Re: Damaged I-Joist

Location: Lot 42 Mason Ridge (189 Calebs Corner Place. Spring Lake, NC)
JDS Project No.: RDU2505175
Date of Inspection: 05/19/25

FLOOR JOIST LAYOUT

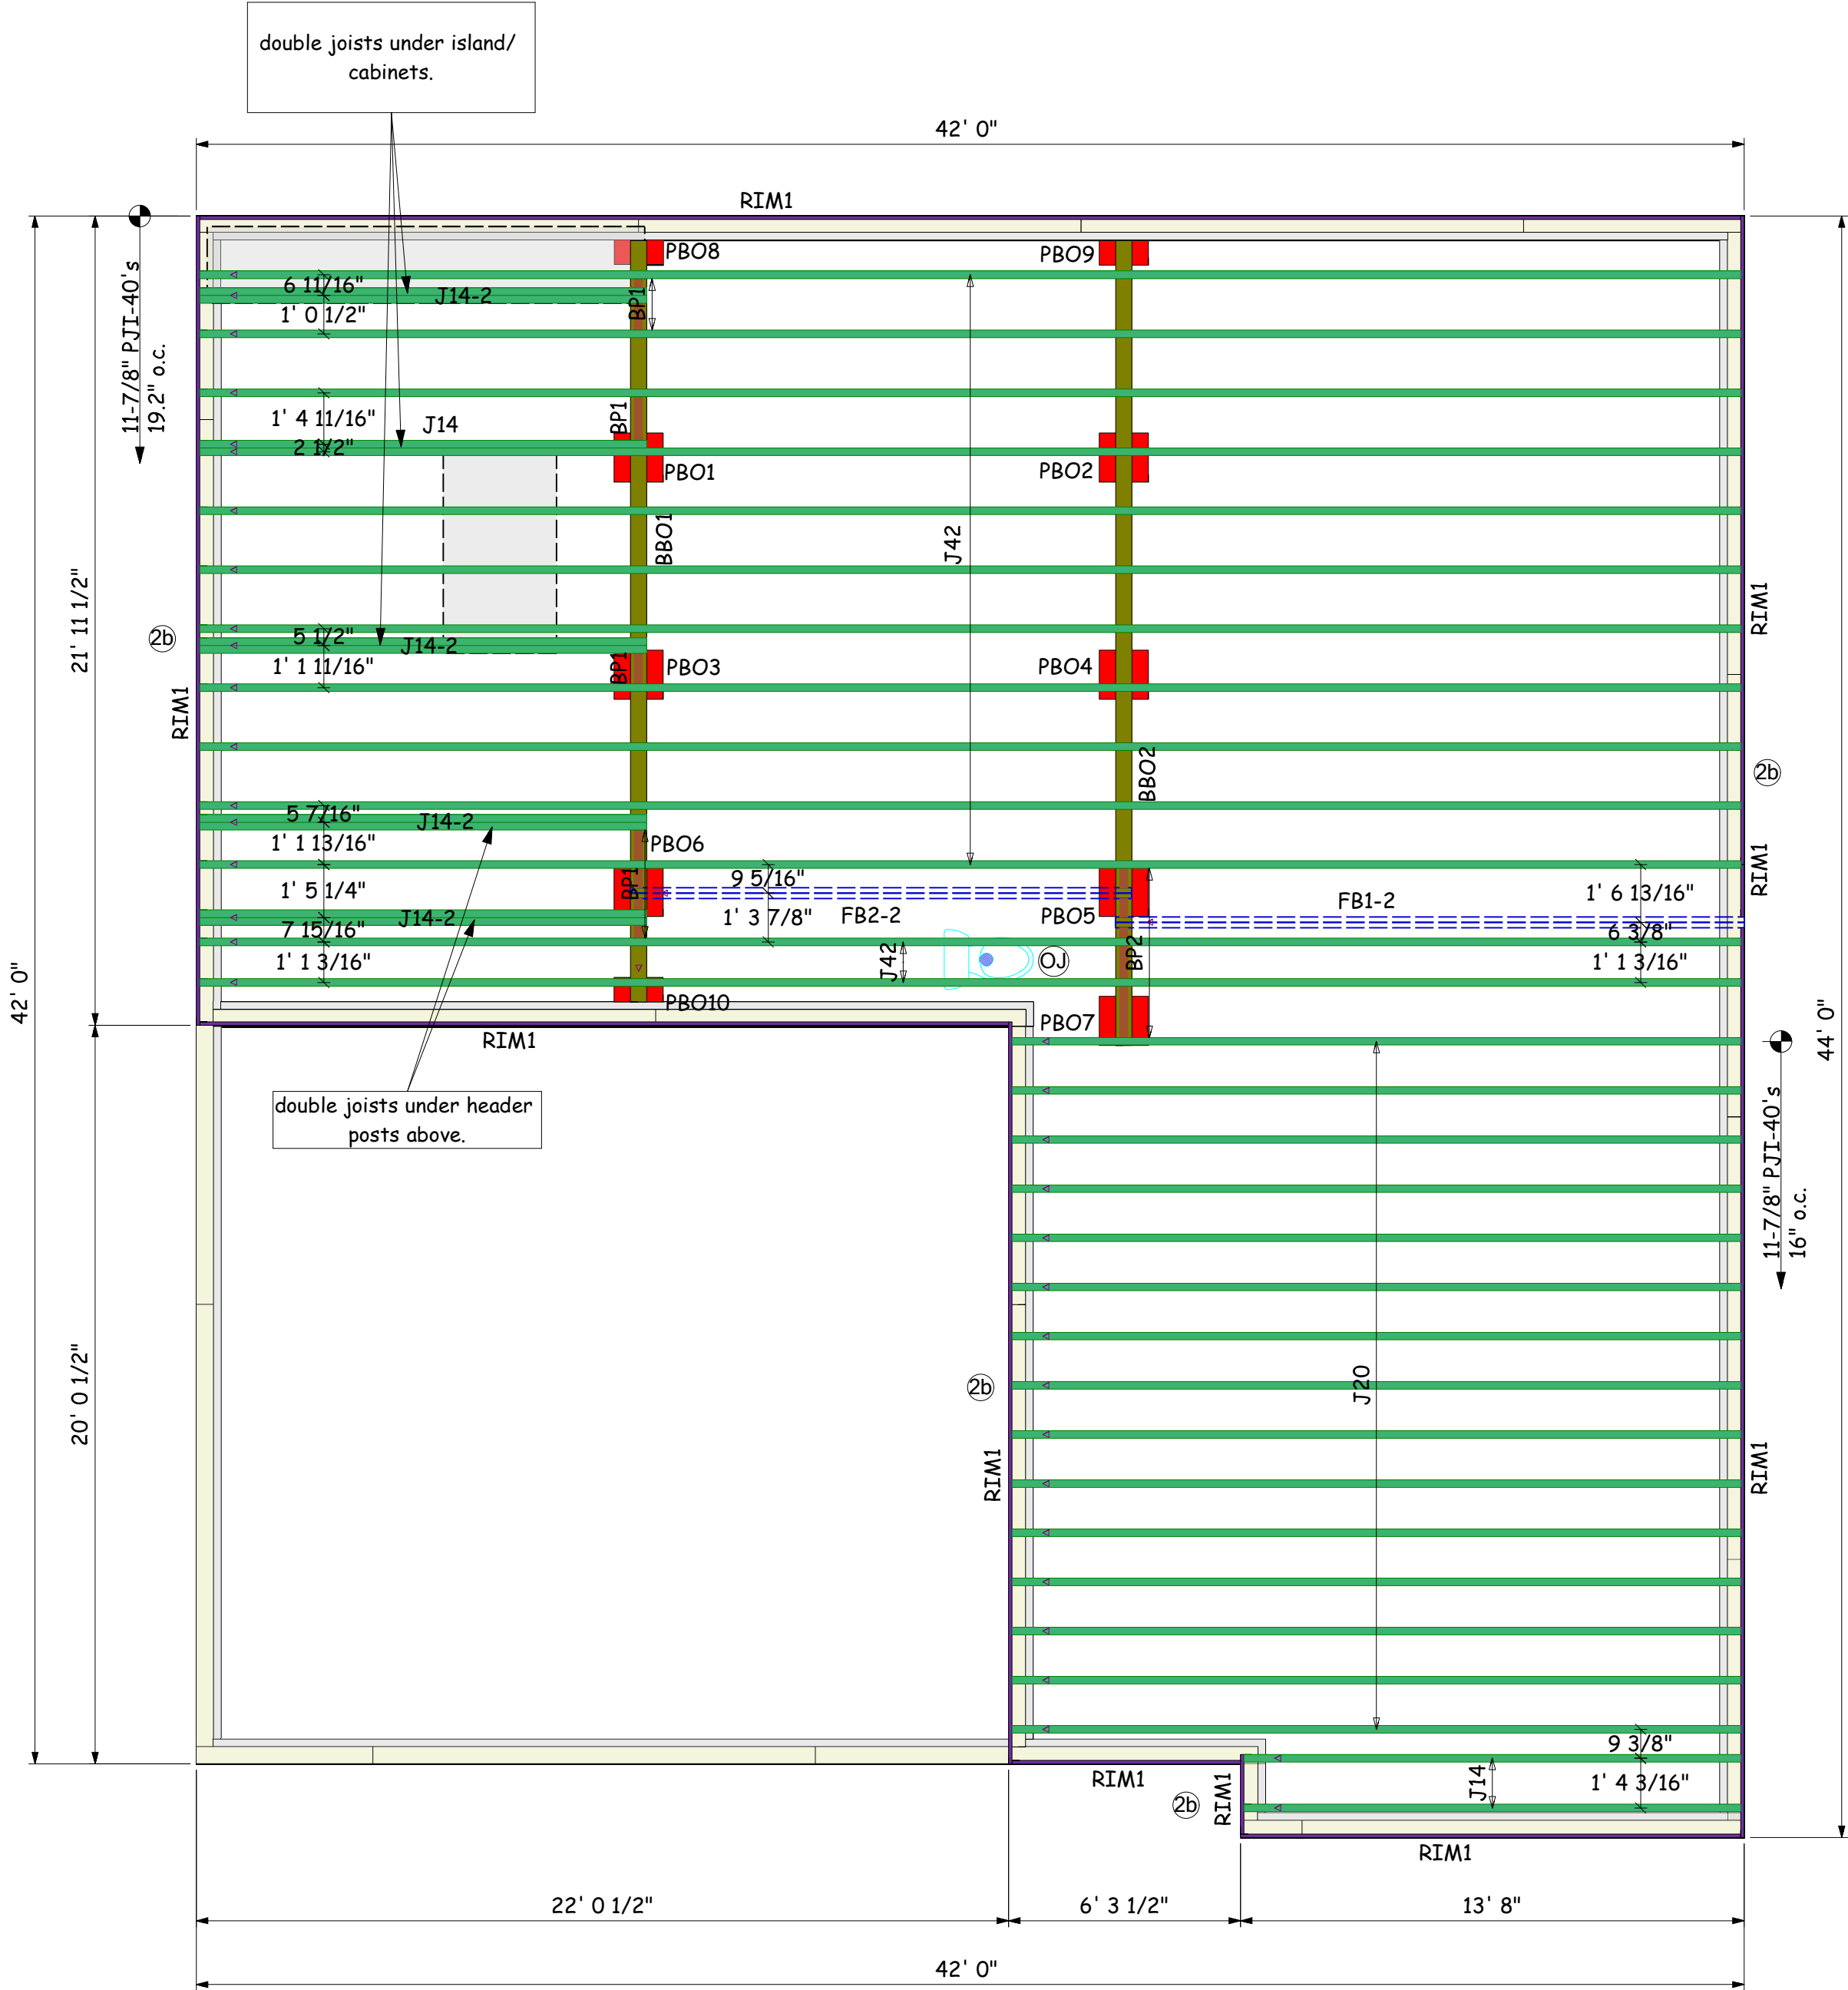
1. The 1st through 10th 14" PJI I-joists spanning over the dining room. Each I-joist has an approximately 10" hole drilled in the web to accommodate HVAC. The holes are drilled approximately 6'-10" from the left bearing end.
2. The 2nd I-joist from the rear dining room wall has too much web material removed and is too close to the bottom flange.

1. Pack out the webs of each I-joist on the accessible faces with full depth 3/4" OSB spanning a minimum of 2' past the damage in each direction and attached with construction adhesive and (3) rows of 6D nails spaced at 4" o.c. The client may tightly notch in a "U" shape around any penetrations.
2. Pack out the I-joist web on both sides with full depth 3/4" OSB spanning a minimum of 2' past the damage in each direction and attached with construction adhesive and (3) rows of 6D nails spaced at 4" o.c. The client may tightly notch in a "U" shape around any penetrations. Install full depth vertical 2x4 scabs on both sides of the HVAC penetrations from flange to flange attached with (2) rows of 10D nails spaced at 4" o.c. on both faces.
